15 August 2018

SWT18/00005  
SF2018/018983  
MM

**SSD-9033 – EXHIBITION - PROPOSED STAGE 3 OF REDEVELOPMENT OF THE WAGGA REFERRAL HOSPITAL, LOT 334 DP1190643, EDWARD STREET, WAGGA WAGGA, HW14.**

**Figure 7.3: Edward Street/ Murray Street intersection upgrades due to background traffic growth**

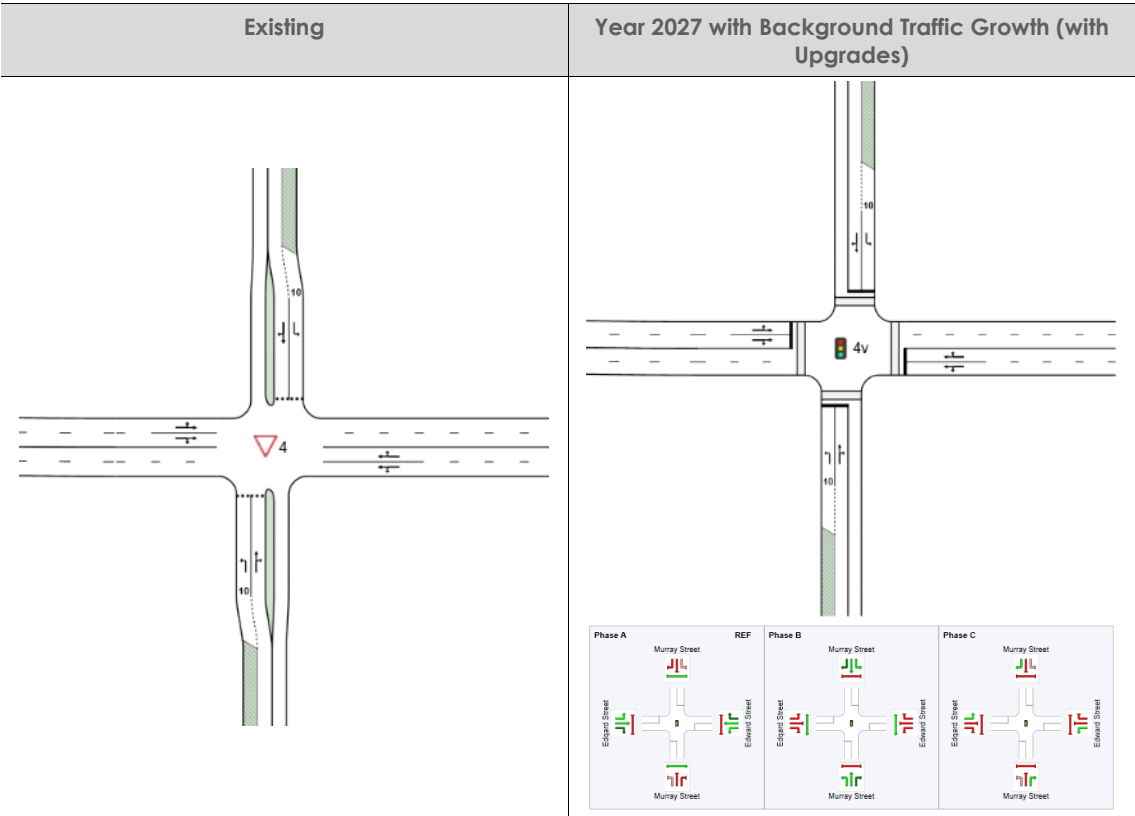
Due to the proposed access routes to the hospital site and the anticipated traffic generation it is considered that the road network within the surrounding precinct, particularly Murray Streets, and its intersection with Edward Street, need to be assessed with acknowledgement of the traffic loadings resulting from the whole redevelopment and appropriately treated to safely manage the increased traffic levels. To further increase the volume of traffic (both vehicular and pedestrian) through this intersection without appropriate intersection treatment will increase the potential for serious incidences at this intersection. The intersection of Murray and Edward Street currently has a crash history. The proposed treatment to deny right turn from Murray Street as proposed does not address the potential traffic issues.

The development should be conditioned to upgrade the intersection of Edward and Murray Streets with consideration for both vehicular and pedestrian traffic however the selection of the appropriate treatment and the level of contribution towards such works will require further investigation and discussion between the proponent, Roads and Maritime Services and the Wagga Wagga City Council.

2. The intersection of Murray Street with Edward Street is to be treated to the satisfaction of the Roads and Maritime Services to maintain a Level of Service C or better in year 20 after completion of stage 3 of the development. The intersection treatment is to be designed and constructed in accordance with the Austroads Guide to Road Design as amended by the supplements adopted by Roads and Maritime Services.

**Figure 7.5: Edward Street/ Docker Street intersection further upgrades (highlighted in blue) due to development traffic**

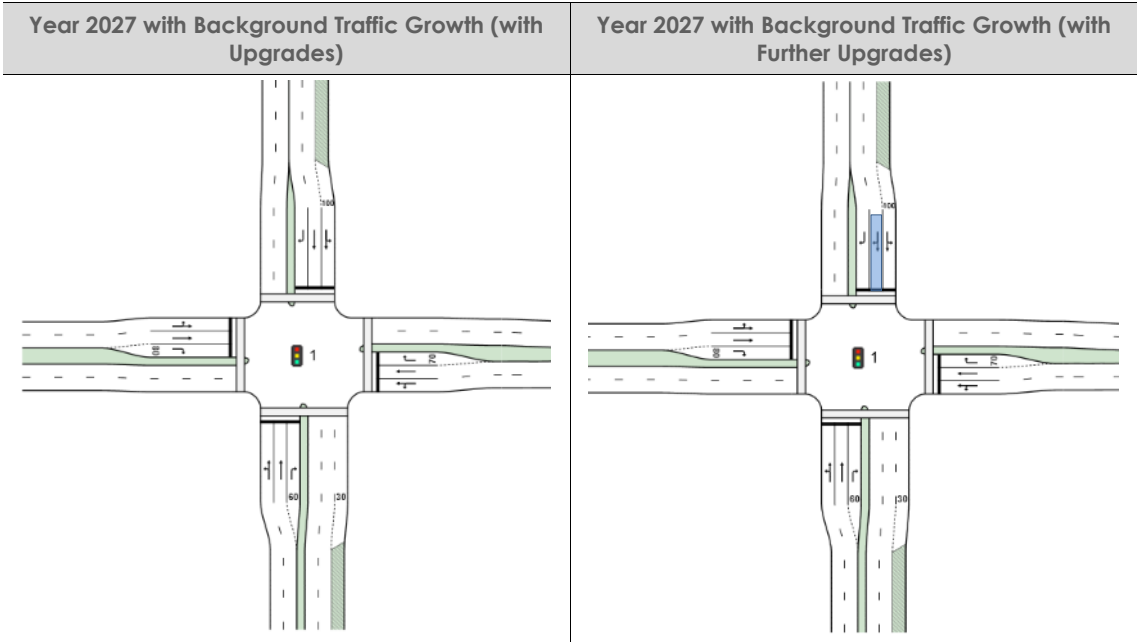
3. Changes to the traffic signals and lane configuration at the intersection of Edward and Docker Street are to be to the satisfaction of Roads and Maritime Services.
